# **Inadequate Treatment of Climate Change and Air Quality in the Environmental Statement**

The focus of this written representation is on Environmental Statement Chapter 13: Air Quality, Chapter 16: Greenhouse Gases and Chapter 18: Health and Wellbeing TR020005.

Diagram 3.3.9: Model performance before and after adjustment, London zone

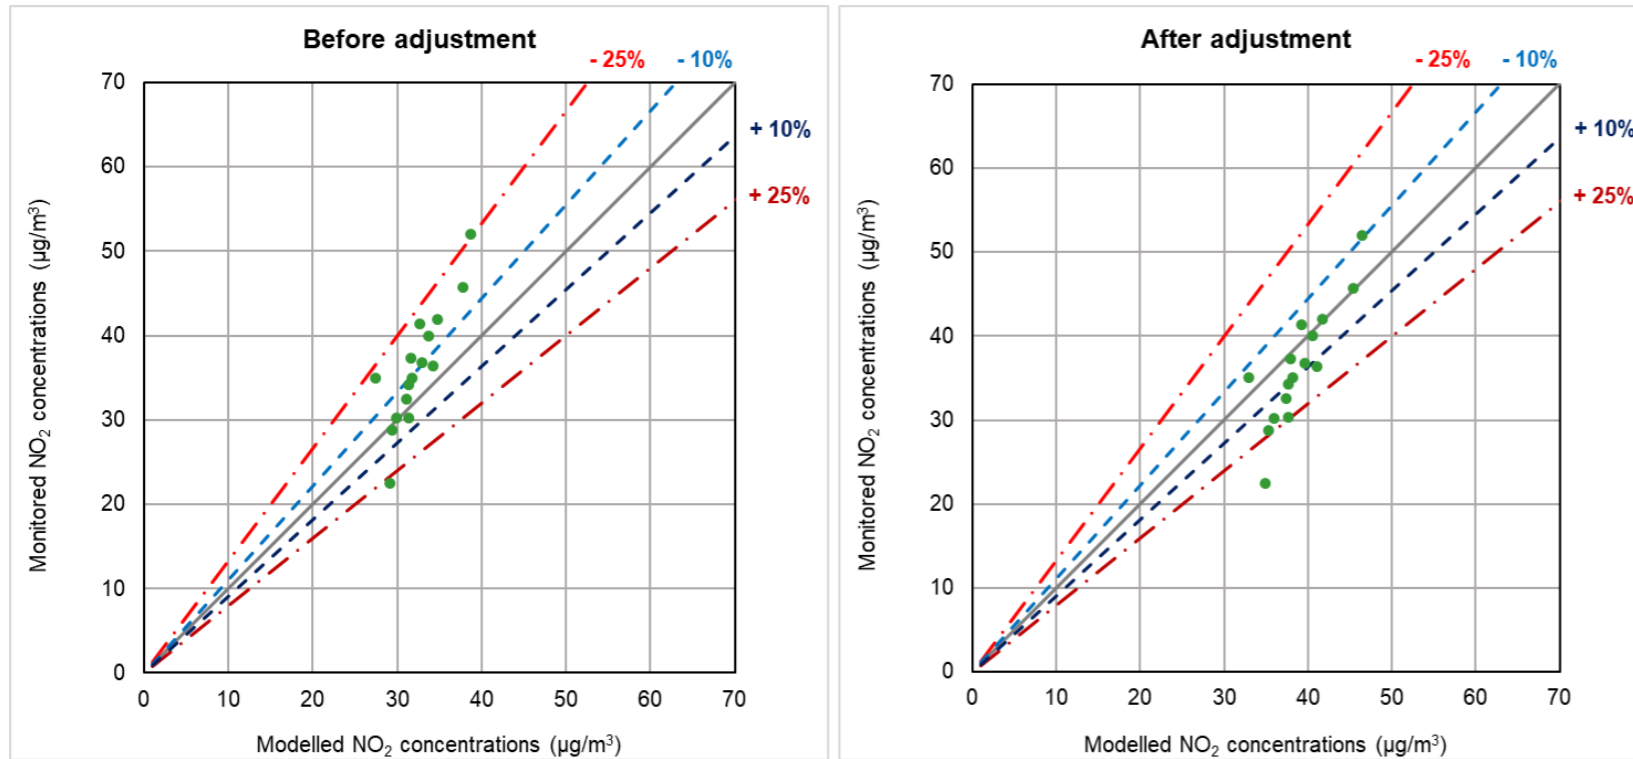
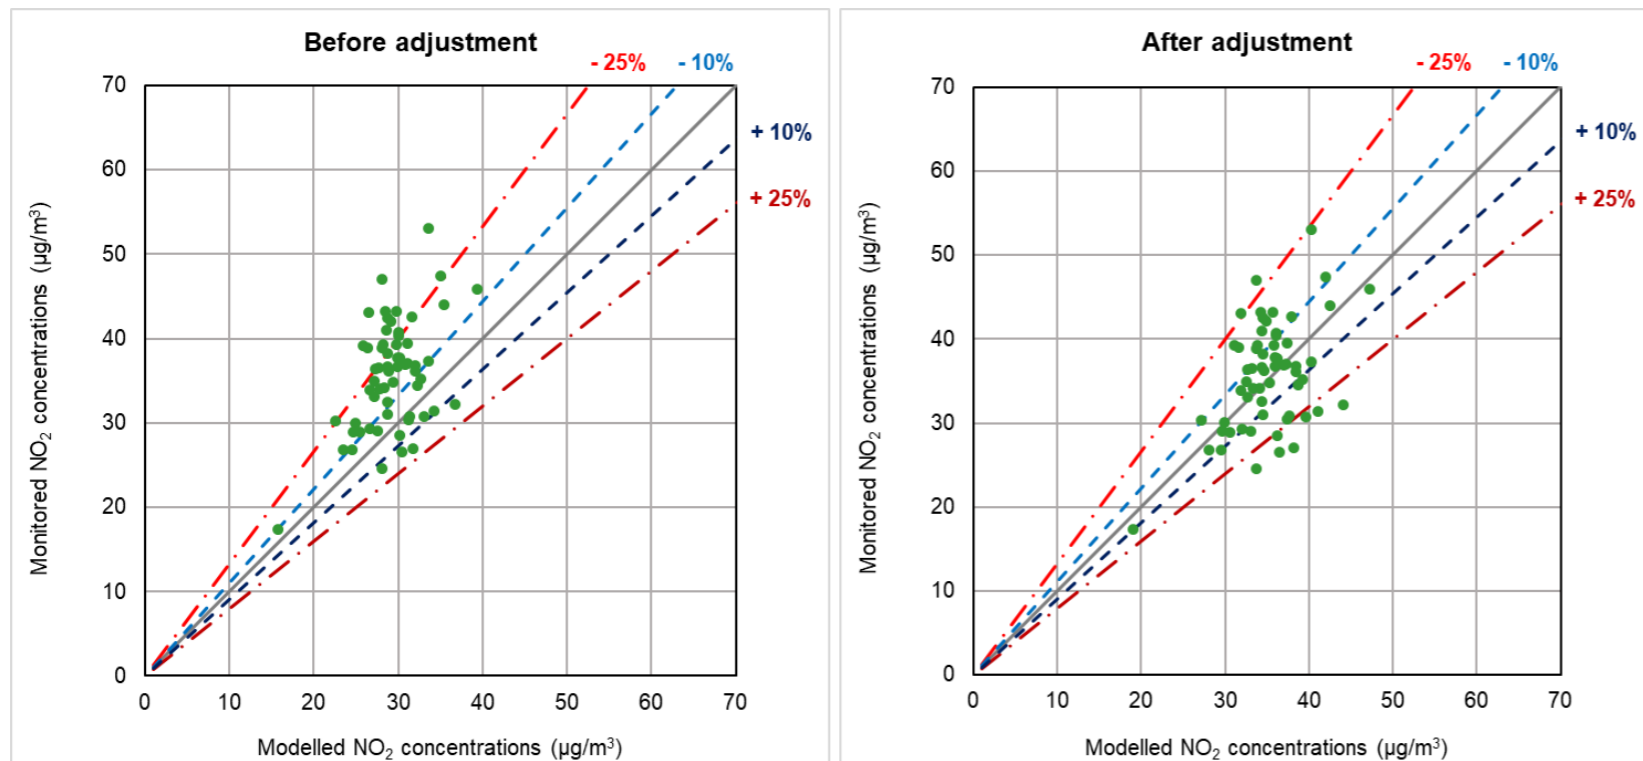
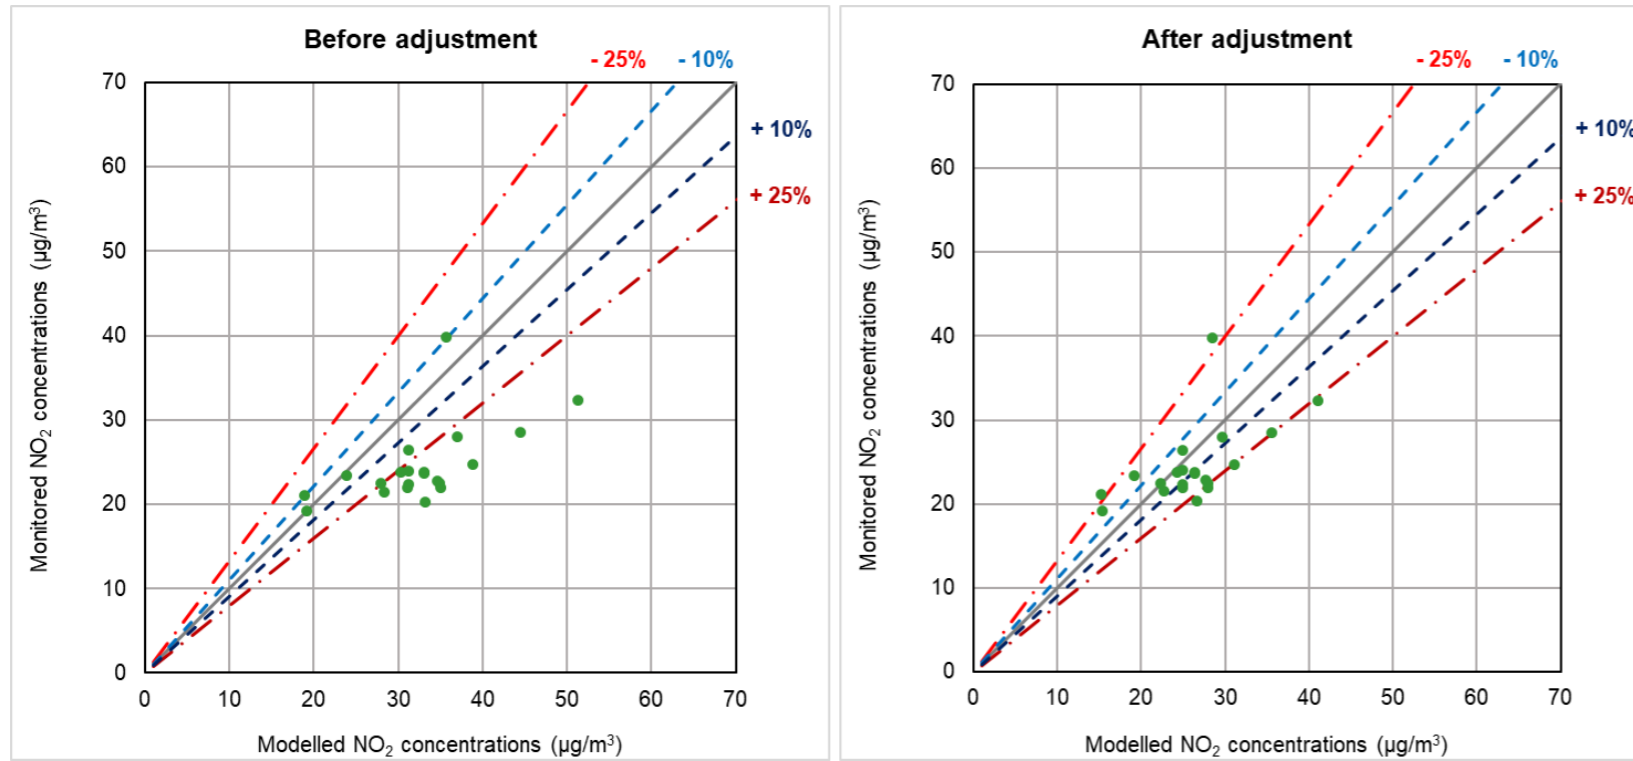
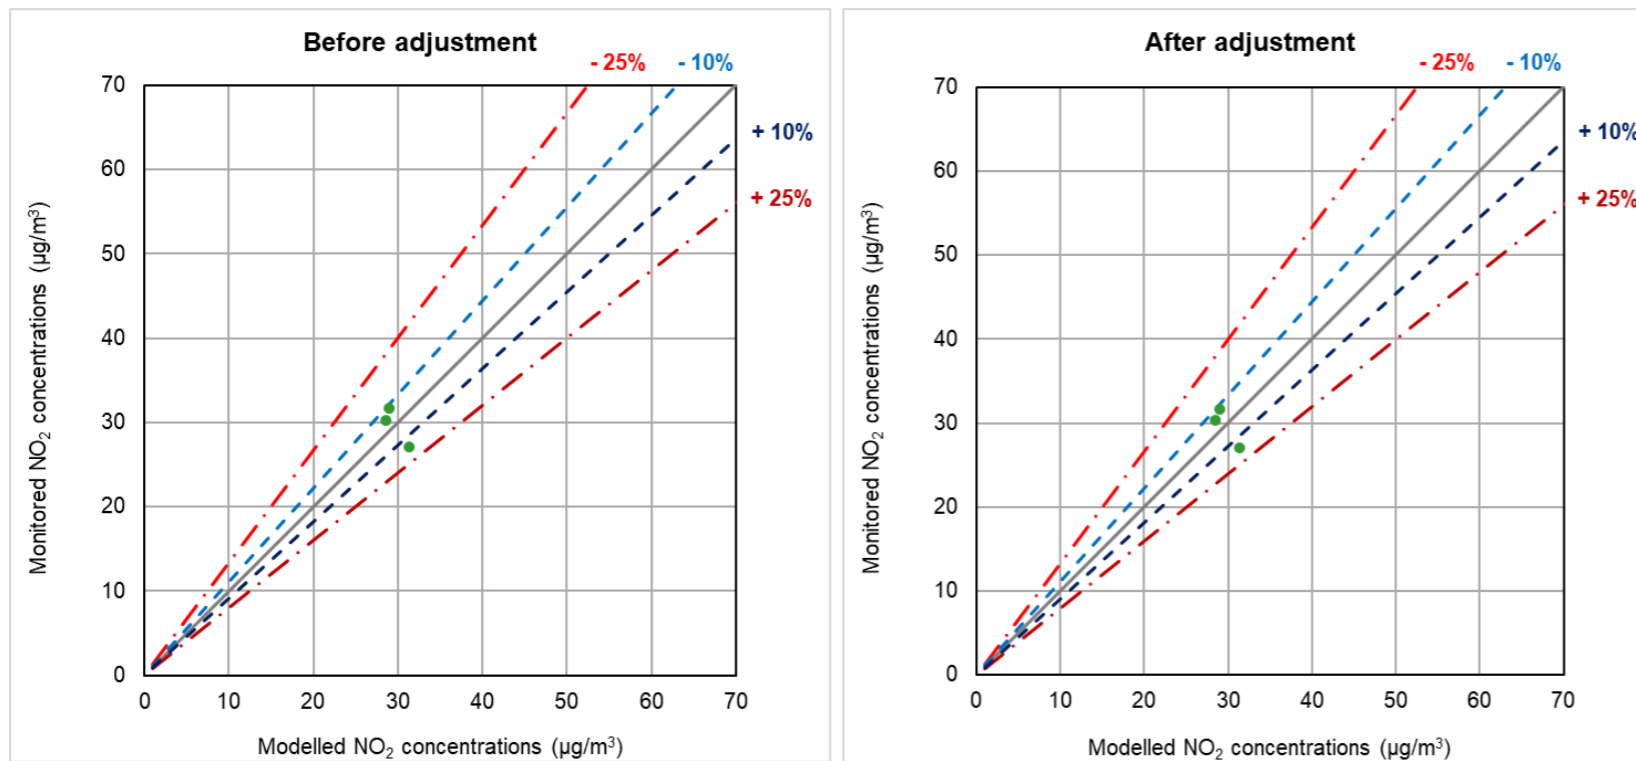
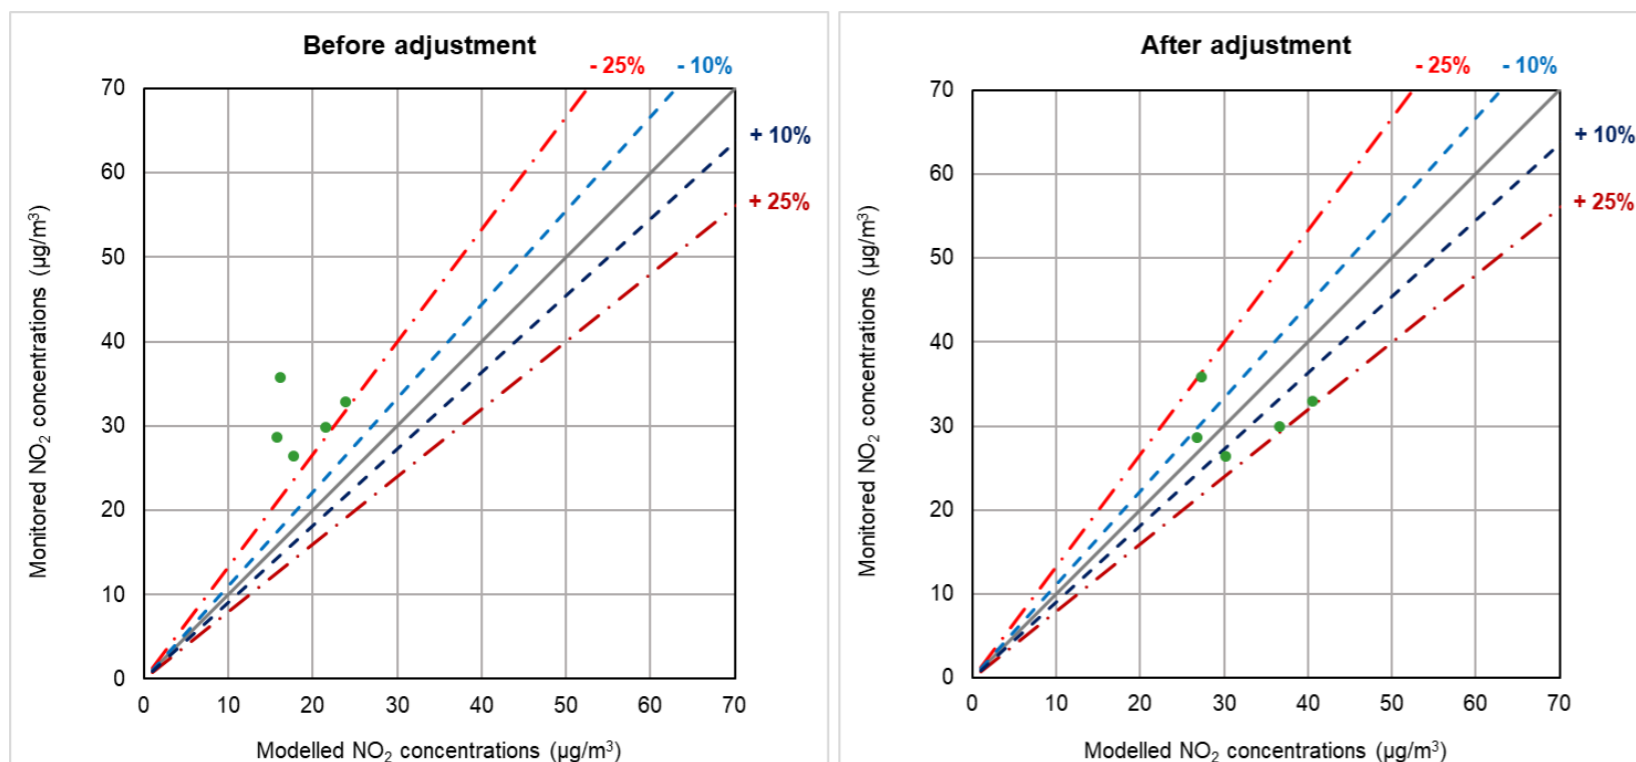
(31) The treatment of the correction to the modelled NO<sub>2</sub> calculations Appendix 13.6.1 of the Environmental Statement seems rather unscientific. If there is a systematic under prediction then some reason should be cited, possibly incorrect traffic emissions. There is discussion in the scientific community of whether emissions based on traffic cycles or real world emissions are best. Appendix 13.6.1 states that the adjustment for poor model performance is a multiplicative factor of 1.2 to 2 and a generic factor 1.3 is adopted. As NO<sub>2</sub>, or NO<sub>x</sub> derived PM<sub>2.5</sub> are the main contributions to the health risk impact (attributable lives lost *per year*) in the health risk assessment, it is important to get the NO<sub>x</sub> modelling right without incorporating correction factors. No results for NO<sub>x</sub> concentrations are presented in

(32) One wonders whether it is valid to apply a poor model, with such poor performance, to future years, if one does not know the reasons for its deficiencies. The Environmental Statement recognises that background air pollution concentrations may change considerably. In paragraph 4.4.3 in Appendix 13.4.1 assumptions regarding future ozone concentrations are made without justification, which could affect future NO2 concentrations.

(d) The modelling of NO2 concentrations is subject to rather **large** uncertainties. One should not use a model to predict future concentrations unless the deficiencies of the approach are understood. The uncertainty is acknowledged in Appendix 13.6.1 but the reasons are unknown.

3.3.1 As described in Section 3.1, there are a number of reasons why modelling and monitoring results differ. At the majority of sites, it can be observed in that there is tendency for the model to underestimate NO<sub>2</sub> concentrations and therefore an adjustment to the modelled concentrations was considered suitable.

One cannot just adjust a model prediction without explanation. Indeed if Gatwick Airport Limited thinks that the air pollution effects are insignificant, Gatwick Airport Limited should build in safety margins and apply these to obtain an upper bound on the expected effects.
